From: Peter Cleveland [REDACTED]
Sent: 15 May 2019 15:37
To: Juan Baeza
Cc: Stuart Corbey
Subject: RE: EP/180/18/PL - The Boathouse, 131A Sea Road & Coastal Caravan Park - for june committee.

From: Peter Cleveland [REDACTED]
Sent: 31 January 2019 16:20
To: Stuart Corbey
Subject: EP/180/18/PL - The Boathouse, 131A Sea Road & Coastal Caravan Park

PROPOSED
FRONT ELEVATION

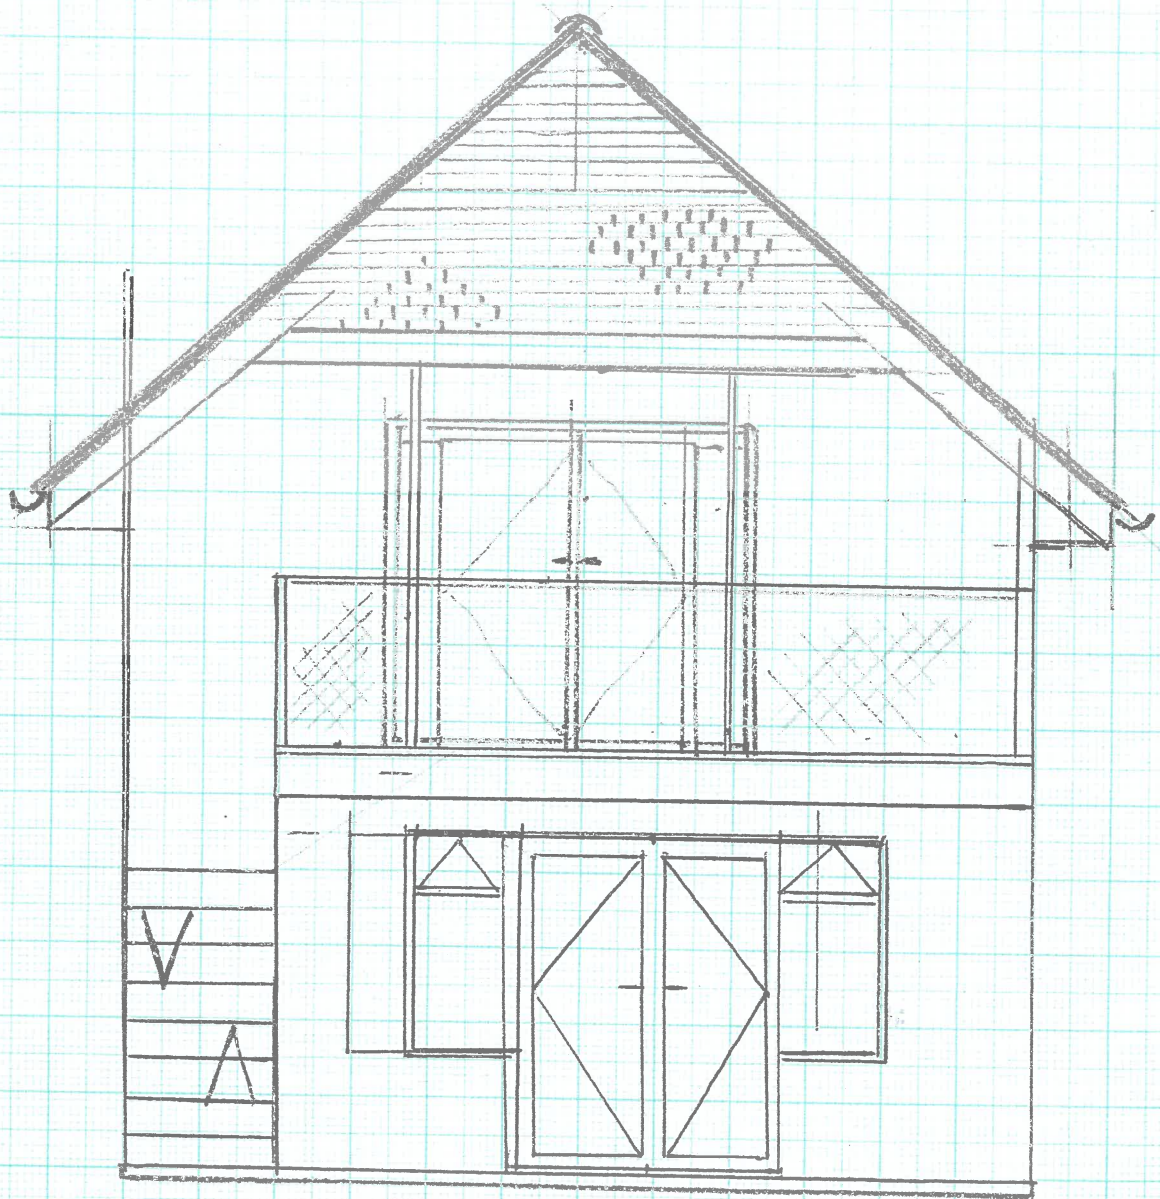
- a) We need the location and block and caravan site plan numbered... (it's helpful if not essential)
- b) The term 'existing and proposed' need to be removed from all other plans - e.g. floor plans et al
- c) The flue added to all elevation plans (as current not shown)
- d) Confirmation that the plan listed as existing front elevation is omitted (as the building has been fully developed, therefore the plan is not relevant)
- e) Can you confirm the relevance of the section plan – demonstrating the concrete foundation – as this in our view can also be omitted if only applies to Building Regulations and thus not a planning matter.

Indicative Site Layout - Drawing No. 3

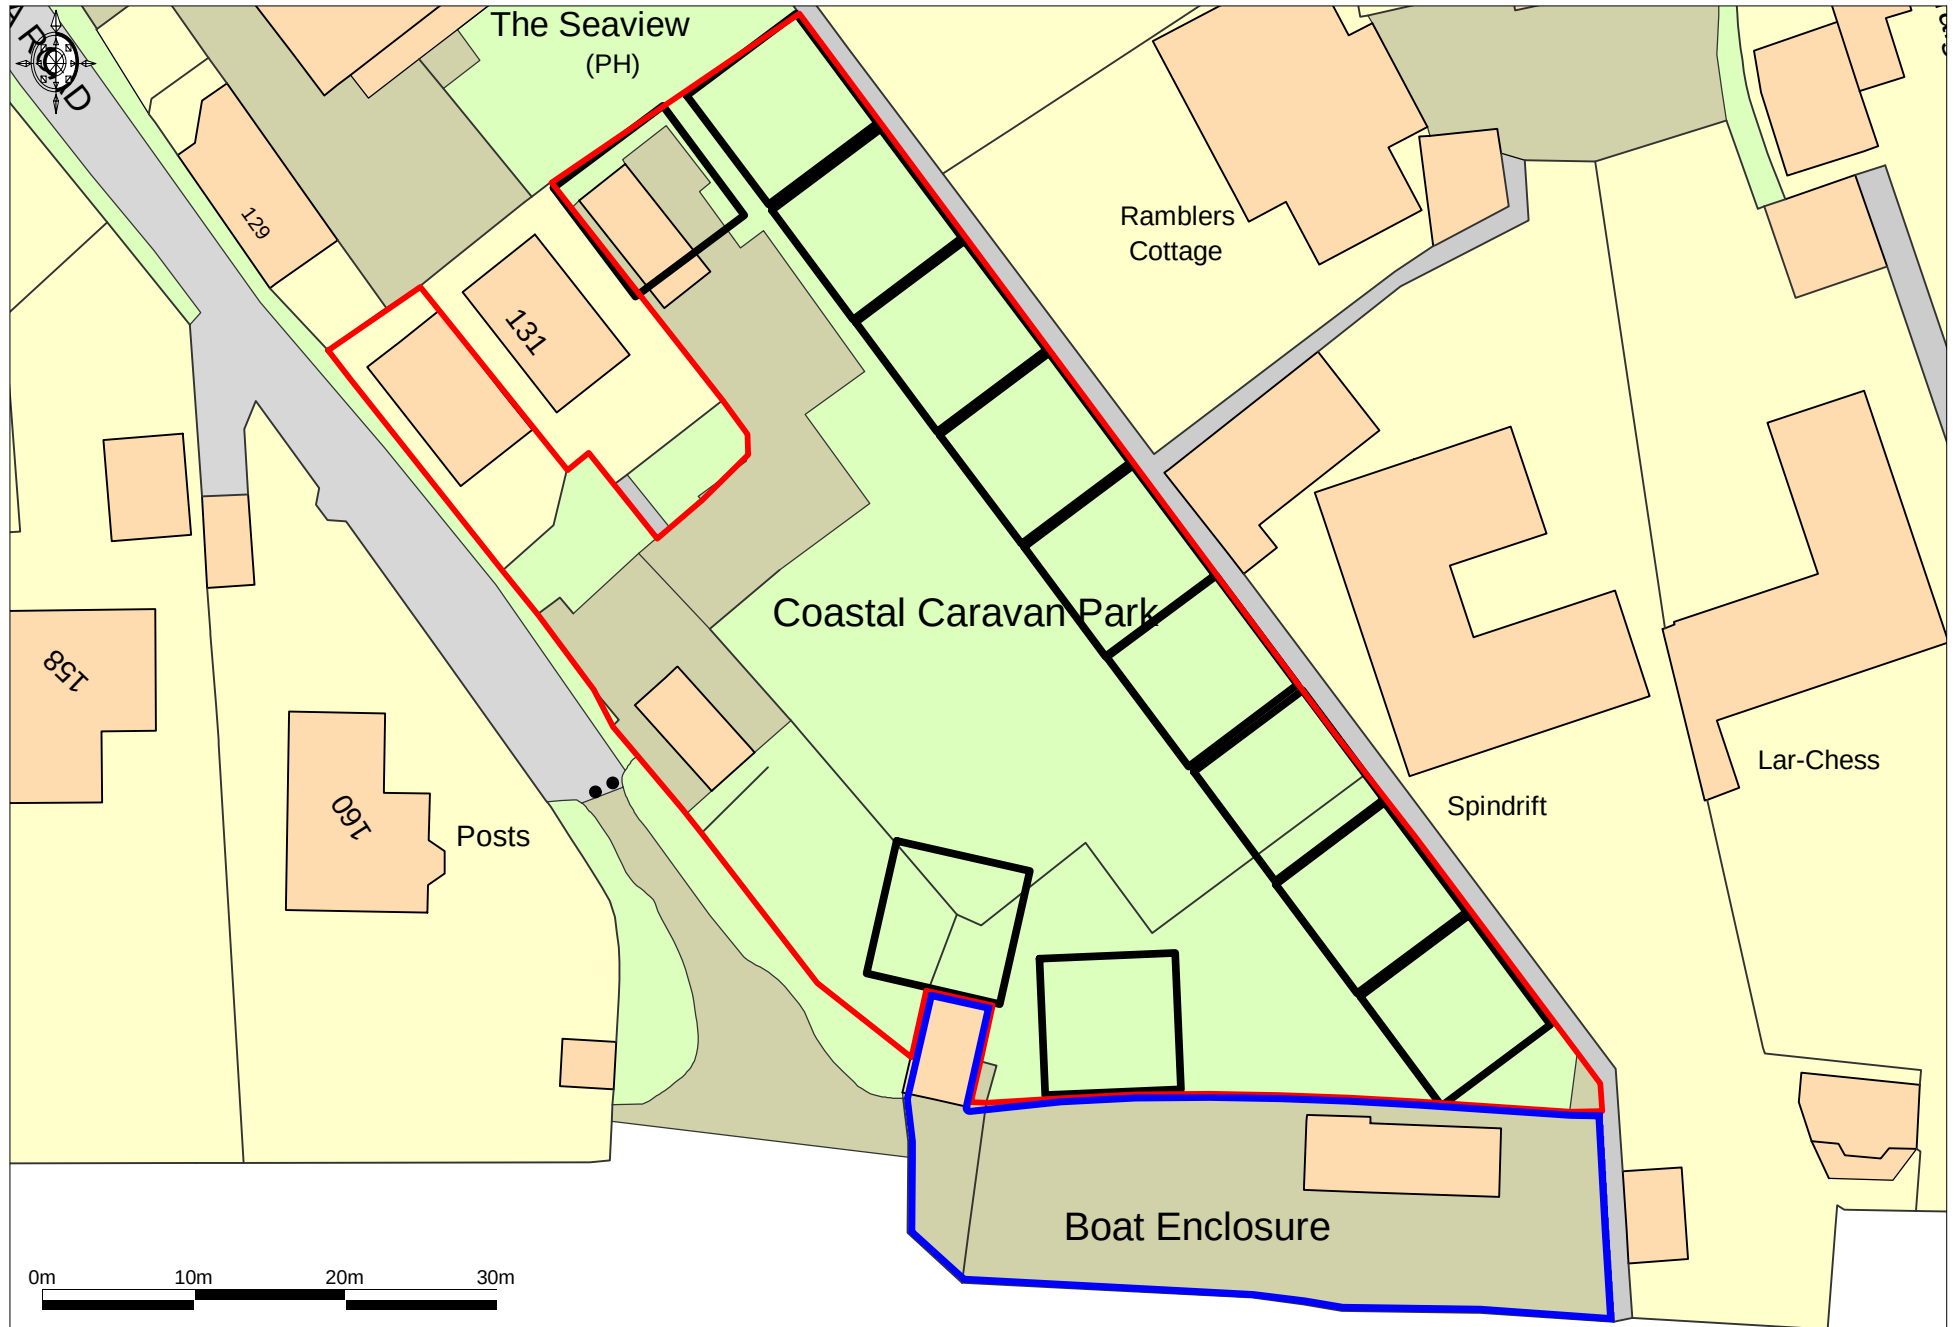
The plan as submitted to us on the 31st January 2019, shall be used as an additional plan, however, this will need to be updated and sent to us with a red line around the whole of the site to match that already submitted-- (Proposed Extension to Caravan Park) plan.
